Dear Sir/Madam,
RE: Lots 18, 20 36, 37, 38,39, 40 & 41 of SP 74416 - 85 George Street,
Parramatta - Proposed Development of 89 George
Street, Parramatta.

**RE: Objection to Proposed development
No 89 George Street Parramatta
Your Reference: MP 09_0128 - Commercial Retail Development**

Planning Direction has been engaged by *Strata Plus Pty Ltd* (Managing Agents for the owners of property No 85 George Street Parramatta.) to review the above development application and to provide advice in respect of the town planning aspects of the proposed development.

01 PLAN - BASEMENT 1
SCALE 1:200
5 CARS

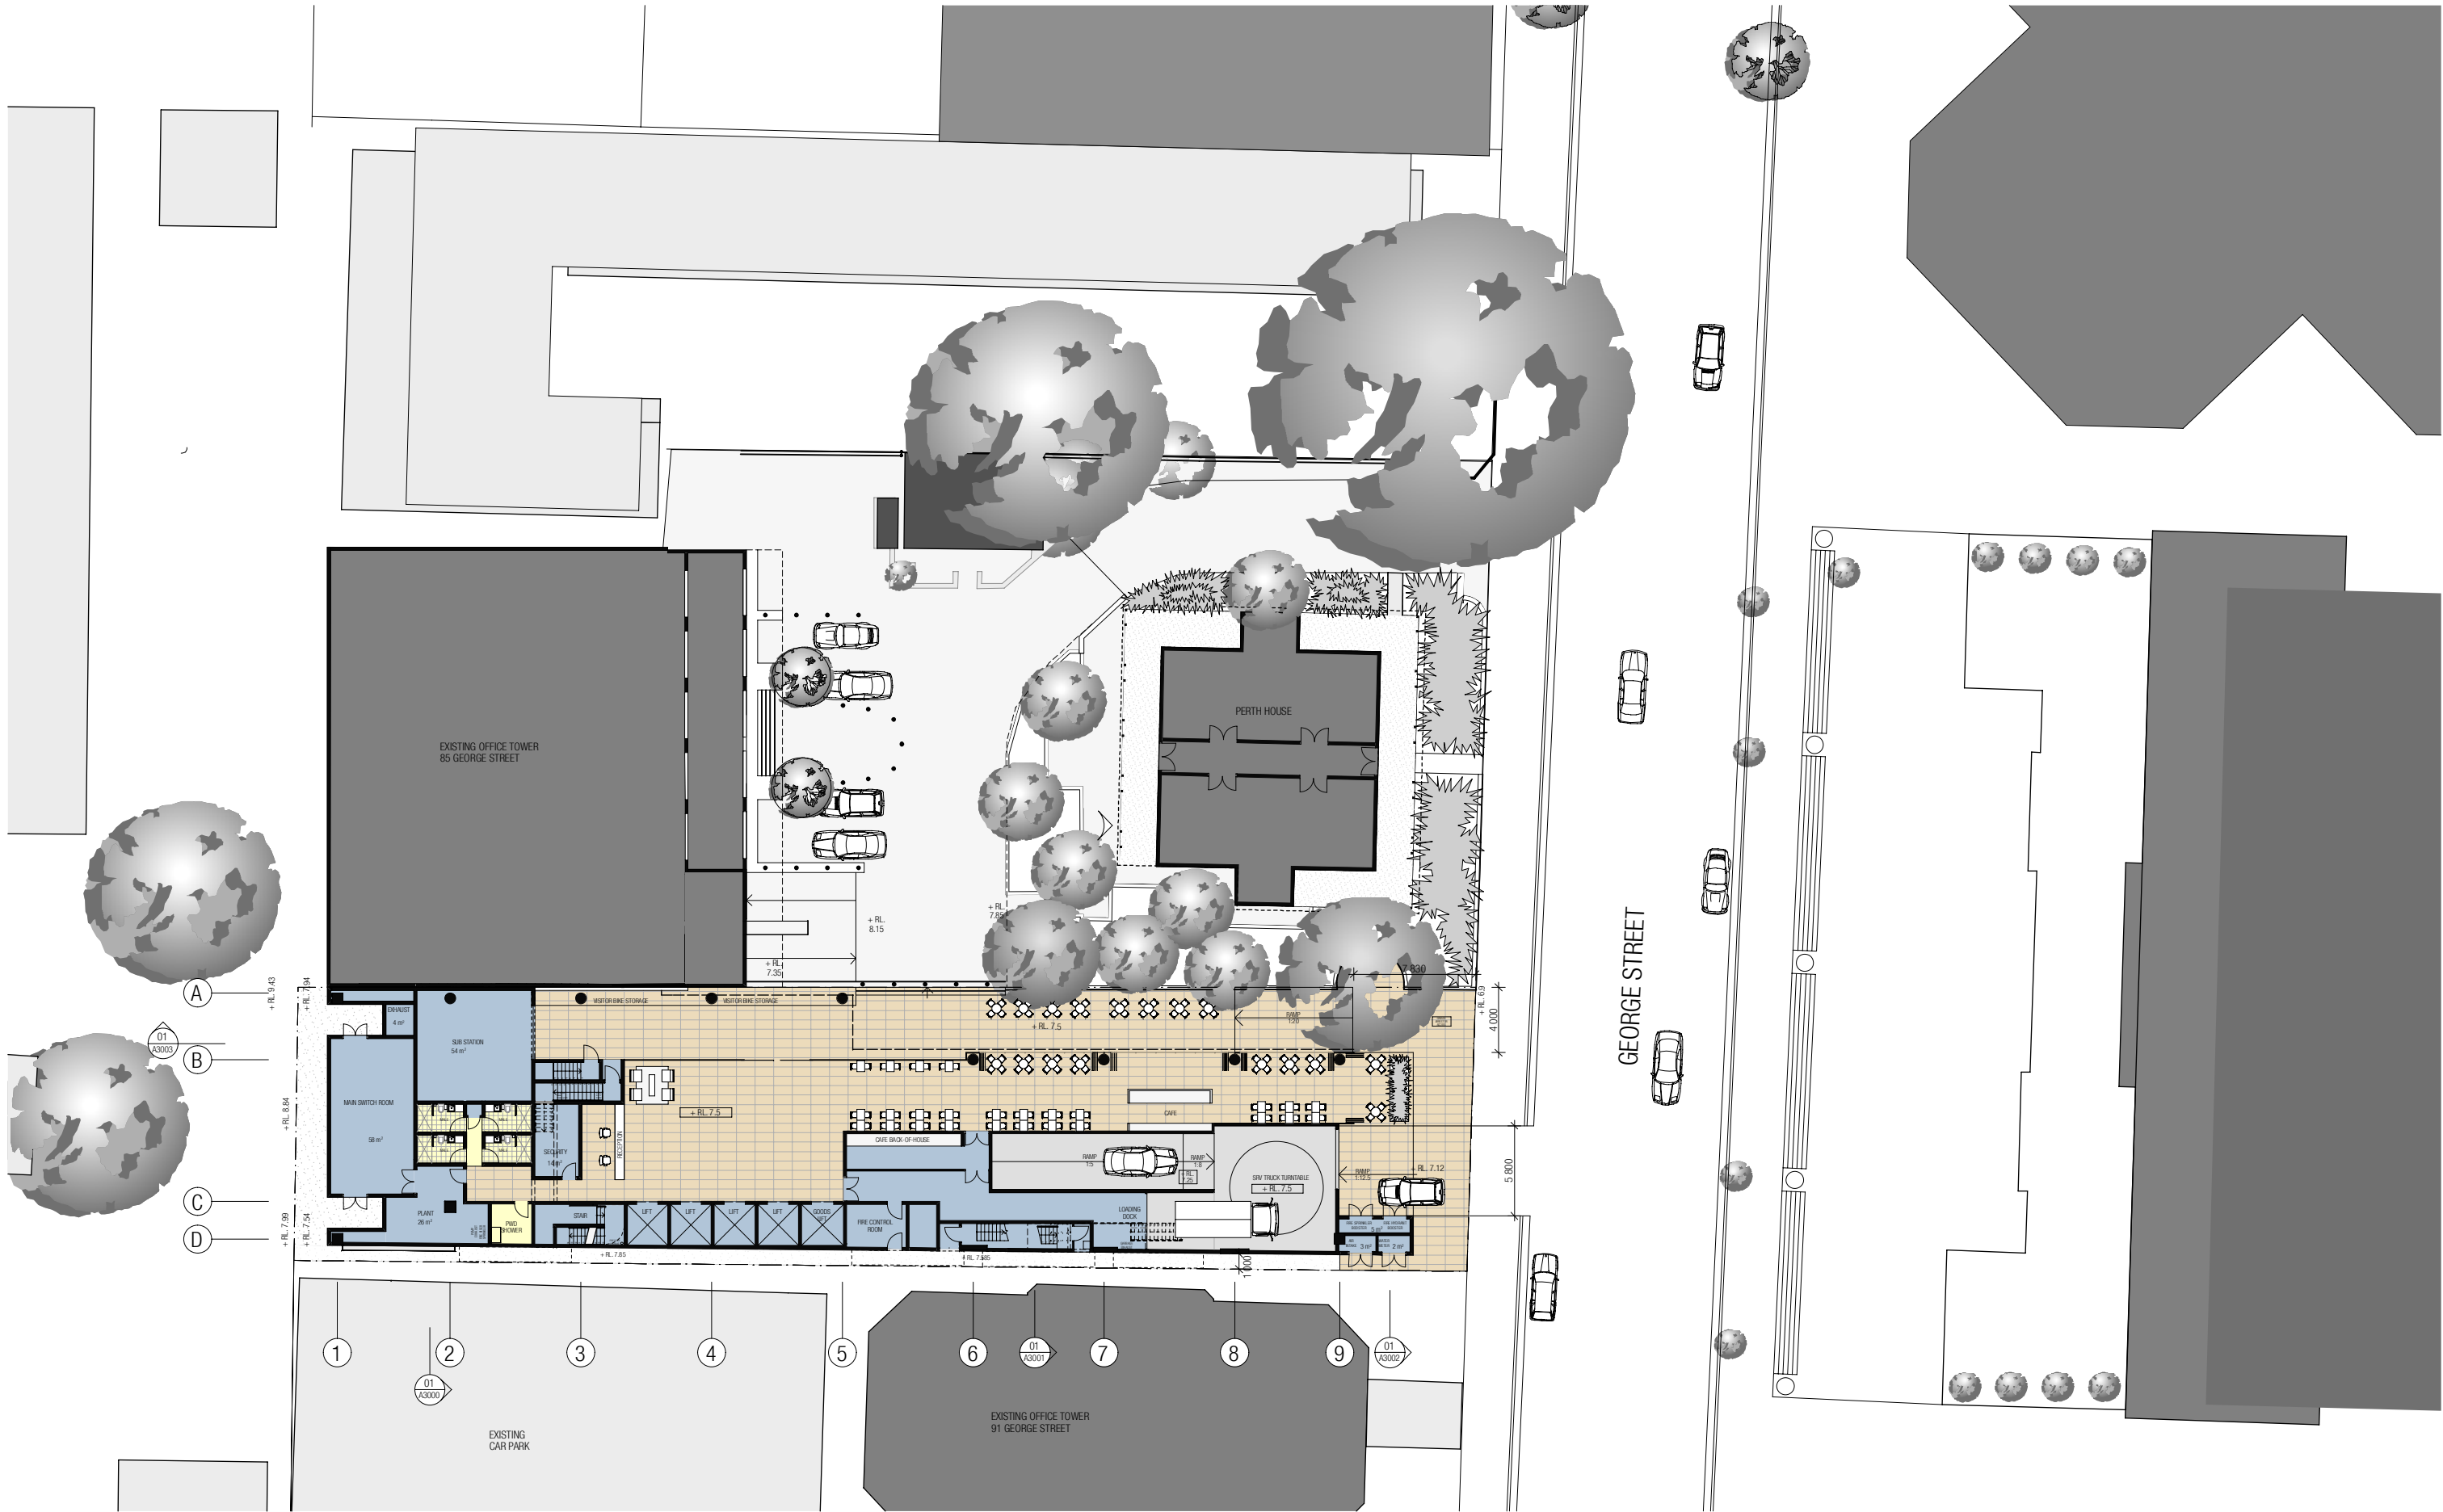
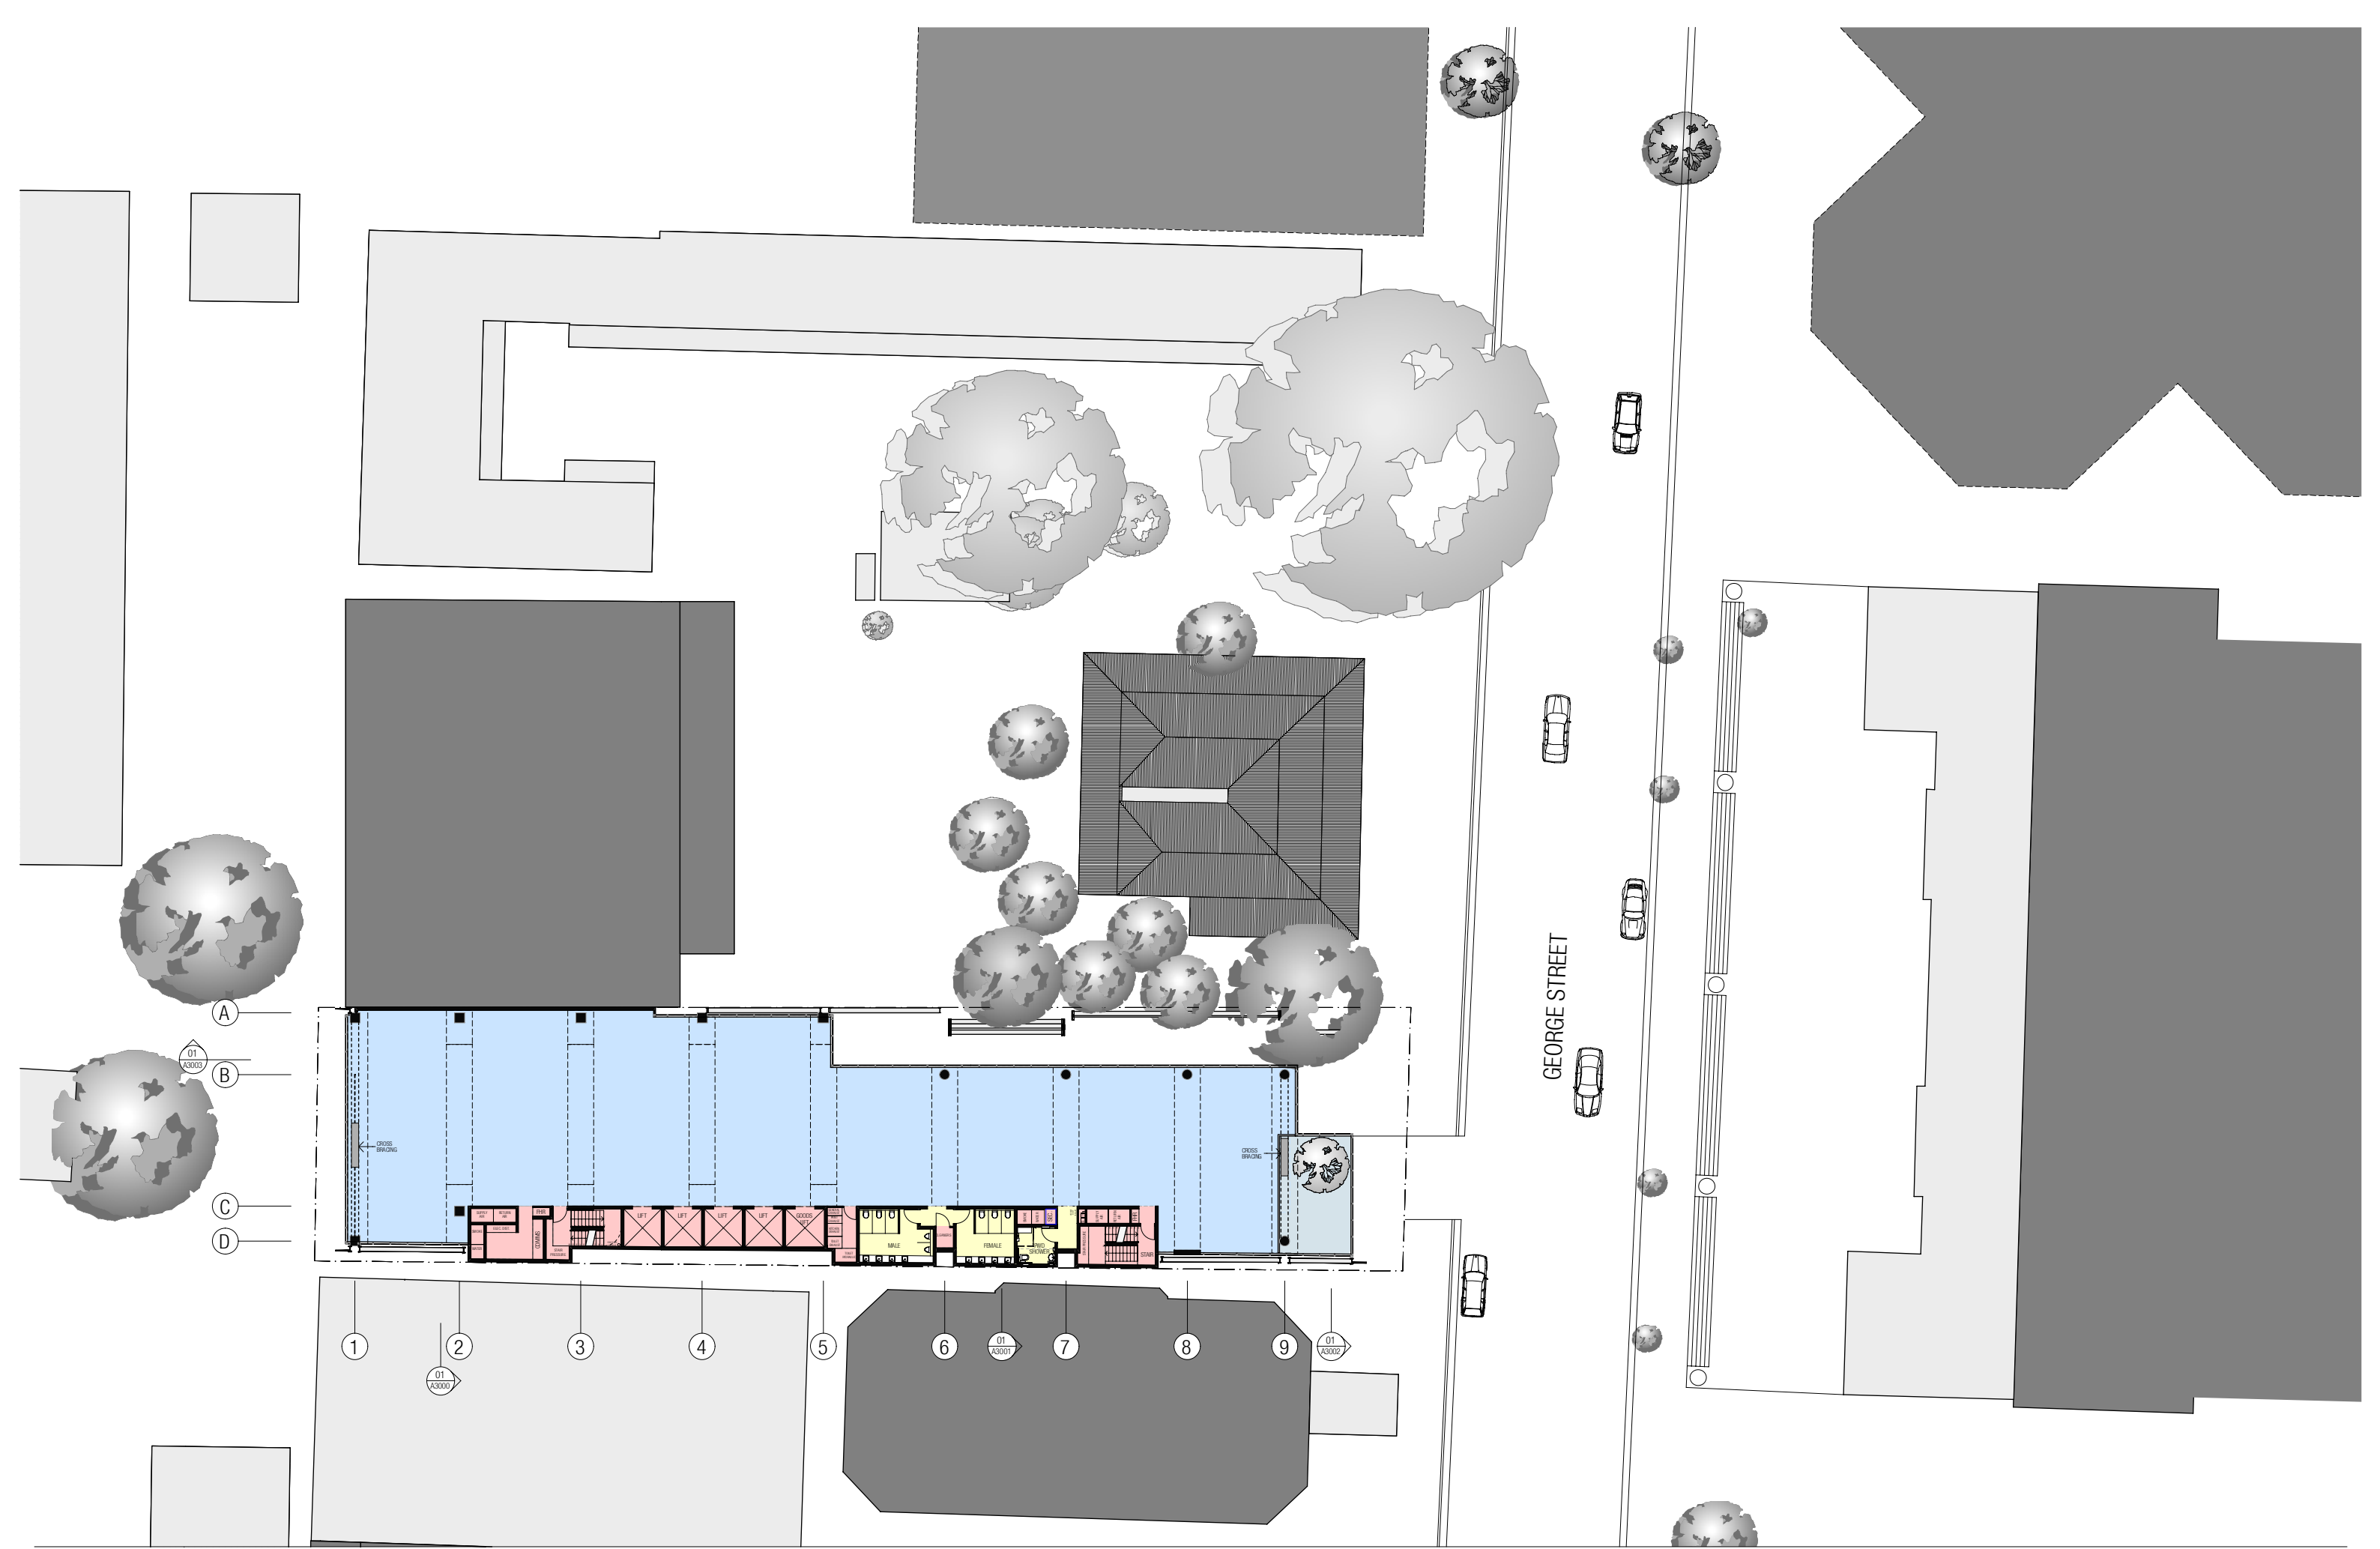
The proposal does not comply with the car parking development standards. The proposed development is significantly deficient in on site car parking.

The previous SREP 28 identified 'maximum' car parking rates, with the change in the planning regime it would seem that there was a deliberate decision to modify the CBD parking policy such that pursuant to the new LEP 2007 a 'precise' number of spaces must be provided for various uses. The proposed development is significantly deficient in on- site parking providing only 63 of the required 125 spaces. This is a deficiency of 62 spaces or approximately 50% of the parking required.

There is no planning justification warranting support of such a major departure from the parking control. The inability to provide adequate car parking facilities on the site is a direct consequence of the additional floor space sought by the proponent and therefore is clearly indicative of the over development of the site.
